Planning Application Ref: R/252/17/T (1) current comments in red

Location : Various Locations throughout the Sea Estate, Rustington

Description of works: Various Surgery & Felling works as listed in application schedule.

SEA ESTATE RUSTINGTON
 PROPOSED WORK TO TREES WITH PRESERVATION ORDERS (TPO'S)
 2017 - 2018
 REFER TO TABLE FOR SCOPE OF WORK

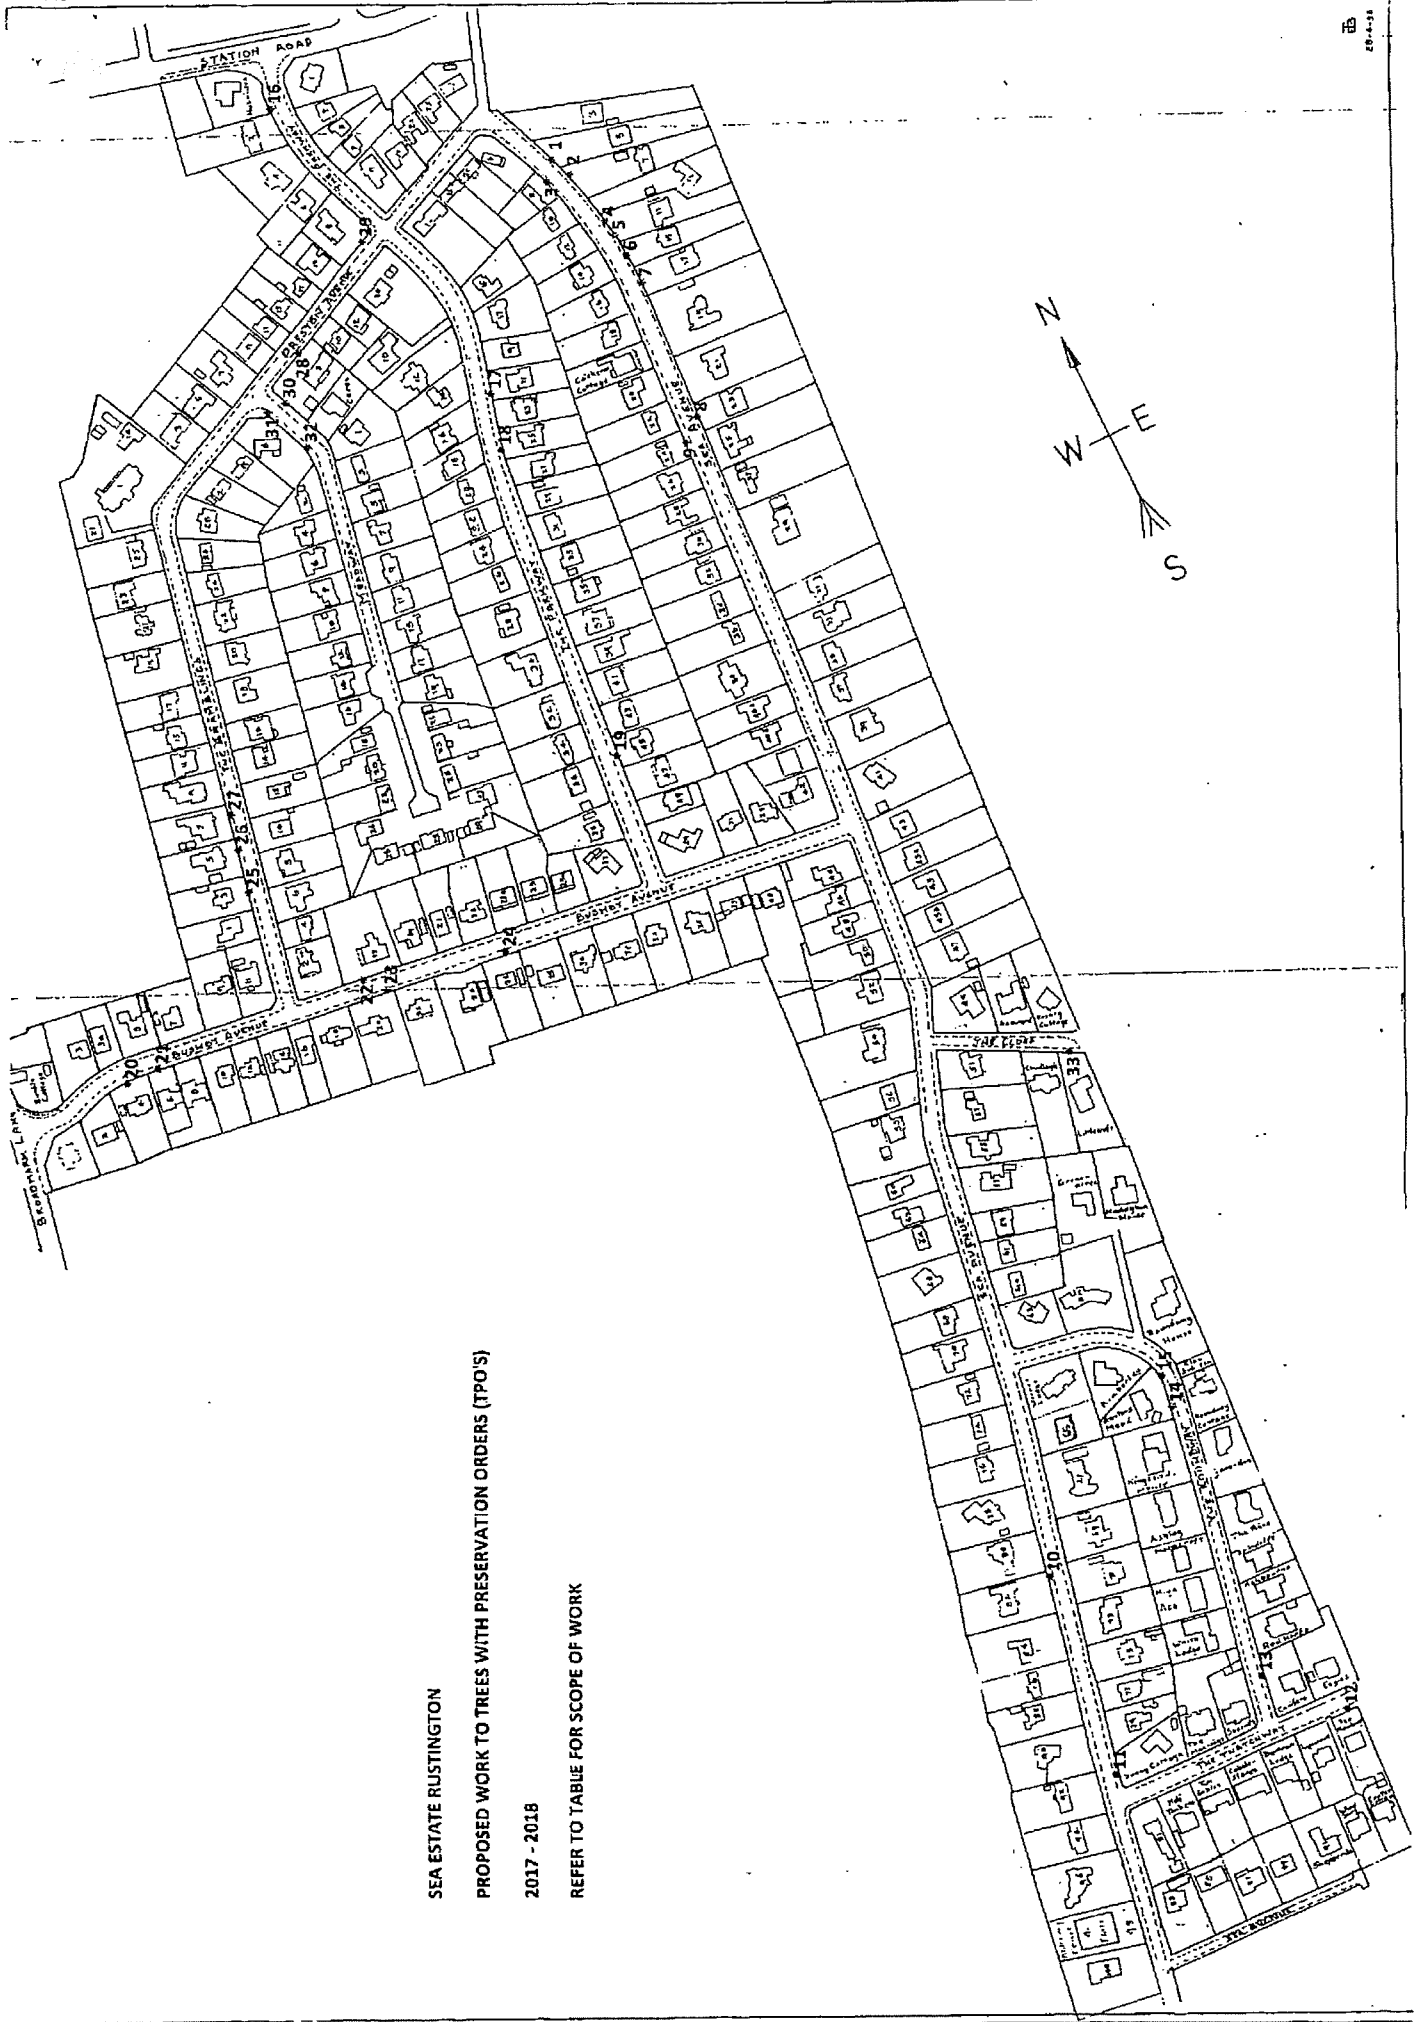
12 – Is listed as an Ash but I only witnessed a Willow and a Tree of Heaven at the location shown on their plan?

28 – It just says crown lift on road side? – we will need them to state to what height above ground and what the maximum diameter of branch is involved.

- The applicants have now re-submitted (Issue 2 revised Jan 2018) seeking the above works specification and providing further details on the trees at Sea Meadows and 8 Preston Avenue.
- I also accept the reasoning for not replanting immediately at 4 Bushby Avenue.
- The application is now acceptable throughout and I recommend **APPROVAL** of same.
